OBJECTION TO PLANNING APPLICATION

Application reference: 2026/62/92200/E

Site: Scholes Cricket and Athletic Club, New Popplewell Lane, Scholes, Cleckheaton, BD19 6NN

Proposal: Formation of two outdoor padel courts and associated works

NOTE: PADEL COURTS TO BE CONSTRUCTED BY SPECIALIST CONTRACTOR IN FULL COMPLIANCE WITH LTA REQUIREMENTS/RECOMMENDATIONS.

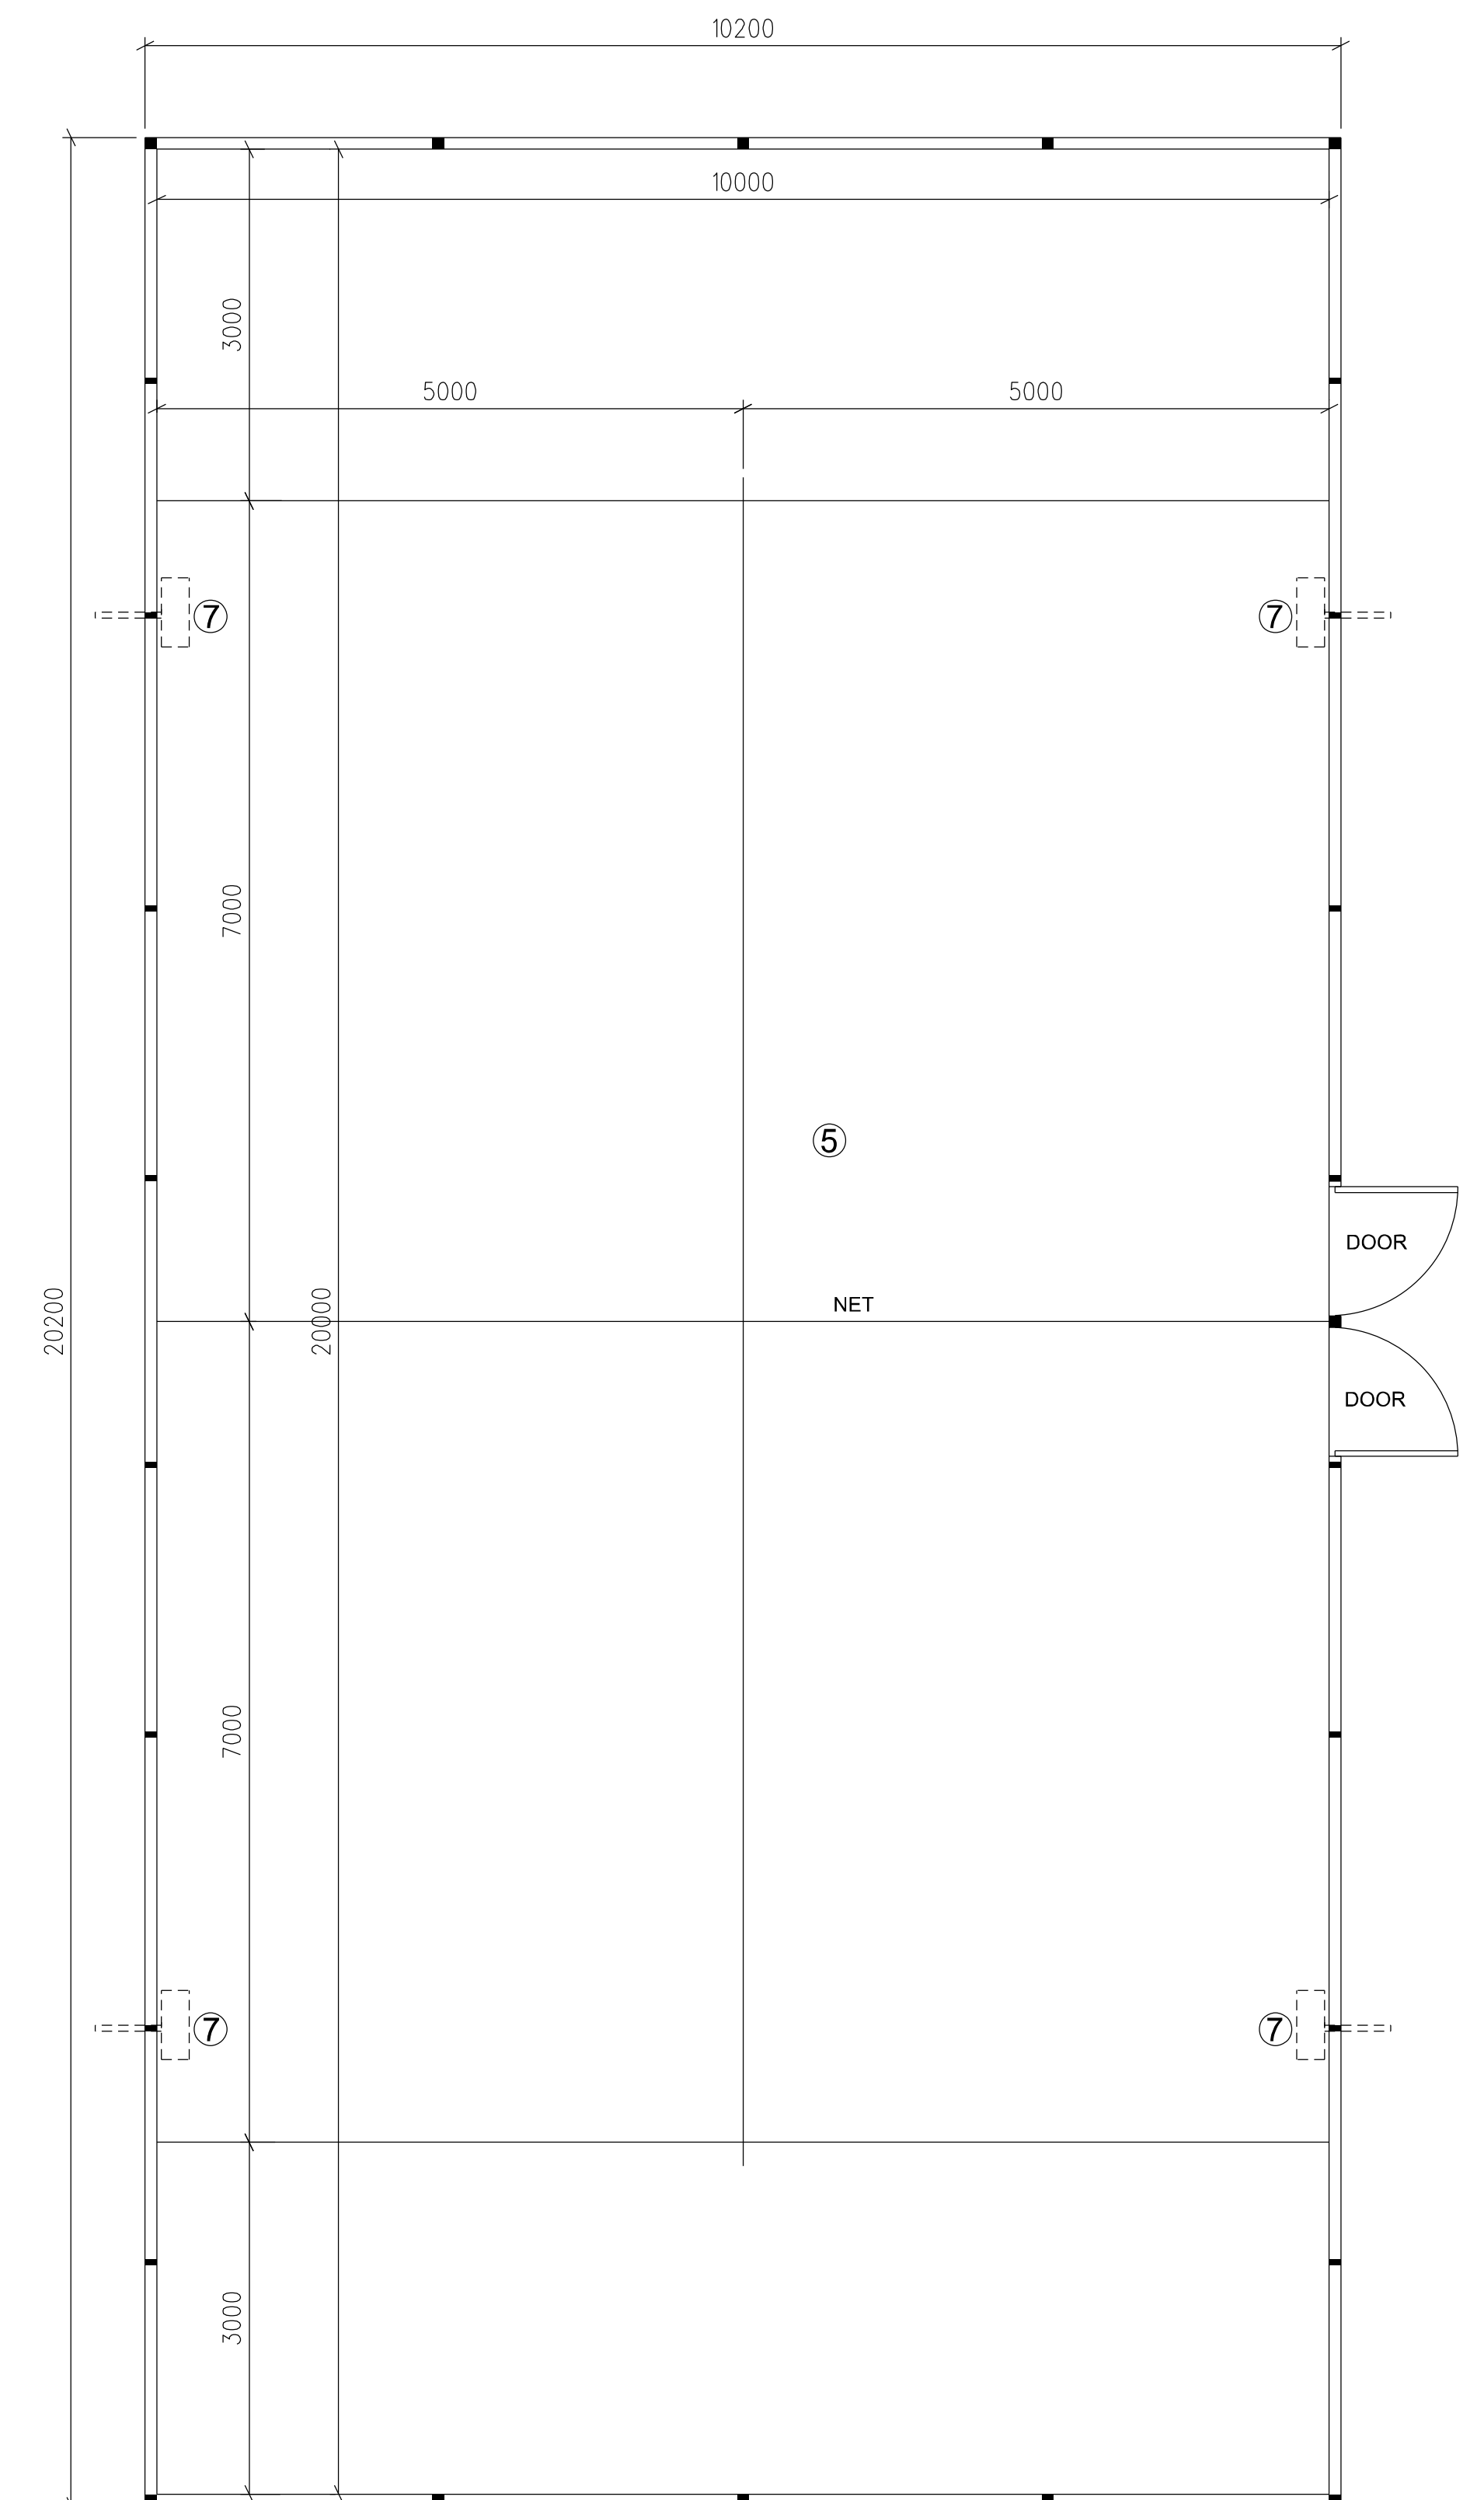
- PDAS paragraph 3.5: *"Floodlights would also be installed."*
- The Padel Court Plan & Elevations (drawing 1155315, Revision A), where legend item 7 reads *"FLOODLIGHTING TO SPECIALIST'S DESIGN"*.

The drawings show four lighting columns per court — eight in total — at **6 metres** in height, with luminaire heads projecting above that. There is no luminaire specification, no photometric data, no isolux or light-spill contour drawing, no predicted vertical illuminance at any residential window, no upward light ratio, no glare assessment, no colour temperature, and no proposed control or curfew arrangement.

- **Height of the development.** PDAS paragraph 3.4 states "*The height of the courts is 4m at its highest.*" The submitted elevations show 6m lighting columns. The tallest element of the development is understated by 50% in the document the Council will rely on for its visual amenity assessment.
